Your ref: 3/2026/0477
Our ref: D3/2026/0477 – Amendment
Date: 12 August 2026

Planning Application No: 3/2026/0477

Proposal: Proposed refurbishment, partial demolition and extension to existing dwelling.

Location: Moorcot, Nickey Lane, Mellor BB2 7HF

Client: Nigel Stones		
Project: Proposed Alterations Moorcot Nickey Lane Mellor		
Dwg title: Proposed Site Plan		
Scale @ A4: 1:200	Date: 24.06.26	Drawn by: PD
Drawing no. 1861 - 102		Rev. B

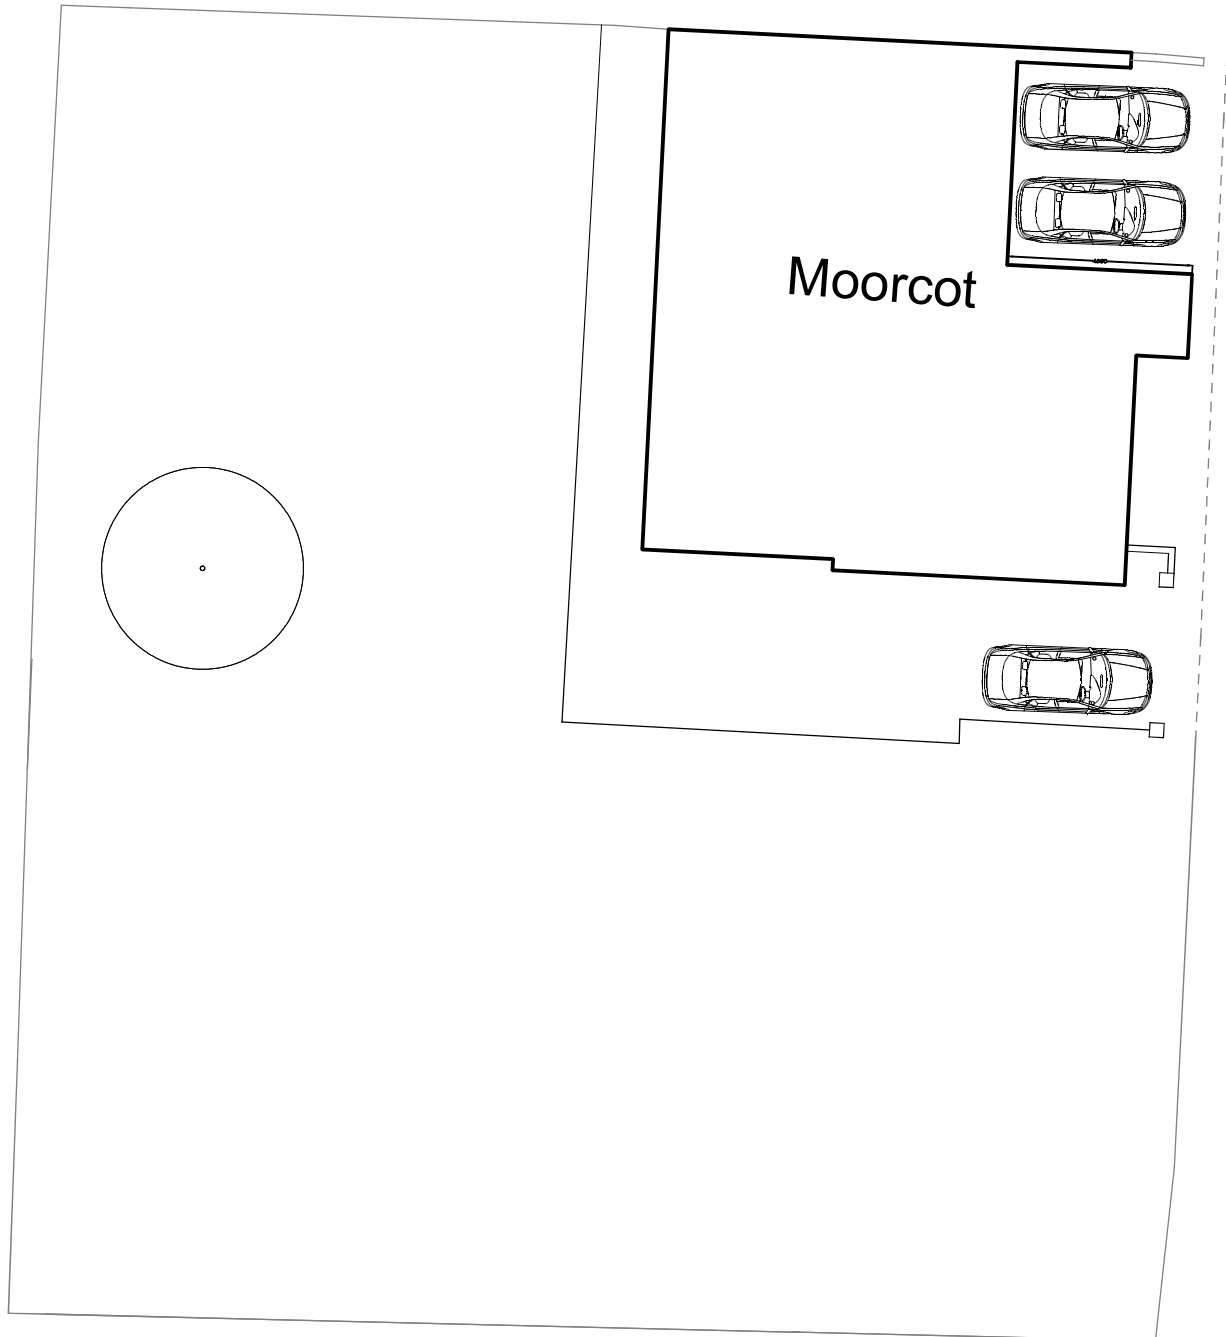
The parking layout to the north east of the dwelling has been amended, which now shows parking as partially under croft/car port. The highway authority has no objection to this layout.

The authority reiterates its comments about the parking areas being surfaced in bound porous material to prevent loose surface material from being carried onto Nickey Lane, where it could pose a hazard to other highway users.

2. Prior to first occupation of the approved development the off-road parking areas shown on the approved Proposed Site Plan (Drawing 1816-102 B) shall be surfaced in a bound porous material in accordance with a scheme which shall be submitted to and approved by the Local Planning Authority. Reason: In the interest of highway safety to prevent loose surface material from being carried on to the public highway where it could pose a hazard to other highway users.
